I refer to your e-mail of yesterday's date in which you set out two relevant considerations concerning the outstanding planning application Ref No. BR/86/20/PL.

Further to my email yesterday, I have been beginning my Officer's Report. Arun District Council's HMO officer have raised the following. I would be grateful if this could be addressed in some form. If you are looking to submit amended plans I would be grateful if this could be done before Monday – this is because the site notice being displayed on site will take place on Tuesday next week and a new notice would be required for the submission of amended plans.

SECOND FLOOR / ROOF PLAN

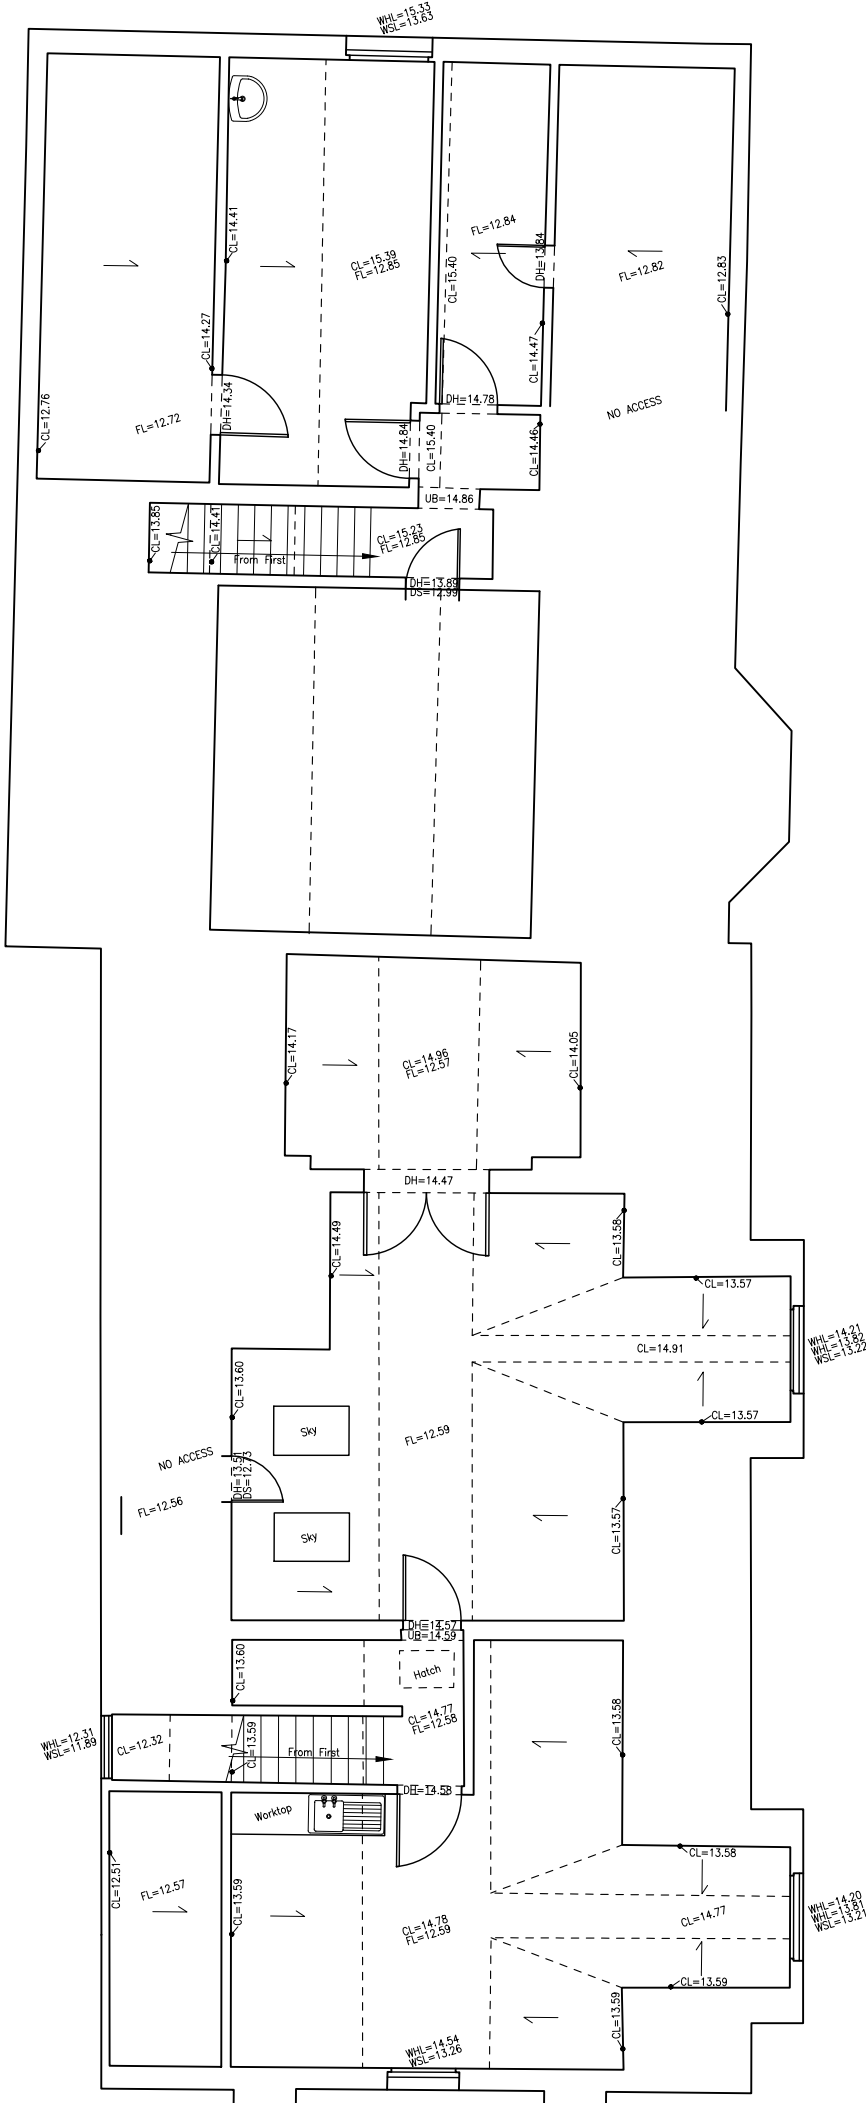
Turning to today's e-mail, I note your HMO officer's comments which concern rooms 36, 37 and 38. It is not correct to say that rooms 36 and 37 have no windows, and for reference purposes I have set out the following details as they relate to views, lighting and ventilation issues concerning the second floor accommodation.

Room 35 enjoys an existing window facing directly onto Nyewood Lane, along with an existing velux rooflight.

Room 36 has two existing windows, one of which faces directly onto Nyewood Lane, with the second window facing the flank elevation of 39 Nyewood Lane.

Room 37 enjoys an existing window facing directly onto Richmond Terrace together with two proposed rooflights.

Room 38 has two proposed velux rooflights. In this respect, I shall be discussing your HMO officer's requirements concerning this room, but I note that your HMO officer states "*velux windows or ceiling/roof casements as the only source of light, ventilation and view should be avoided where possible*".

It follows that with the exception of Room 38, all rooms at second floor level have at least one existing window which is not obscured by any neighbouring development and for which a view, light and ventilation can be obtained, thereby meeting the requirements of the Housing Health and Safety Rating system. It is only in the case of Room 38 that rooflights are the only source of light and ventilation. All velux rooflights whether existing or proposed will be able to be fully opened for ventilation during spells of prolonged heavy rain or snow without allowing rain or snow to enter the room.

It seems to me given the issues raised by the HMO officer concerning the second floor accommodation, that it is room 38 which requires consideration, and even in this case I note the words "*where possible*" act as a caveat to his/her requirements. I should be grateful if you could seek the HMO officer's comments on the information set out above relating to views, light and ventilation to the proposed second floor accommodation.

I should add that if it is found necessary, my clients would be willing to omit Room 38 and if so, we will need to provide you with amended plans by Monday. I should be grateful for your early response to the points raised in this e-mail regarding proposed second floor accommodation. If necessary please contact me by mobile if I am not in the office. To the extent that my client may wish to contact the HMO officer, it would be helpful if we could have his/her e-mail address or direct telephone number.

Velux Windows and ceiling/roof casements

- From the plans, it could not be determined if sufficient natural lighting would be available in rooms 36, 37 & 38. Room 38 does not appear to have any windows with a view proposed, only roof lights. **This is not considered acceptable.** Velux windows or ceiling/ roof casements as the only source of light, ventilation and view should be avoided where possible. If the roof lights are the sole source of light and ventilation, alternative windows will be required to be installed and may be included within stipulated conditions on the HMO licence.

Note: All velux/ ceiling/roof windows must be able to be fully opened for ventilation during spells of prolonged and heavy rain or snow without allowing it to enter the room. Each velux window must also have integral passive ventilation for ventilation even when the window is shut. The Housing Health and Safety Rating System (HHRS) states as a relevant matter that "there should be a reasonable view out of all rooms, other than those where privacy is required, such as bathrooms and WCs", as this can have a negative effect on the mental health of the occupants, especially over the longer term.
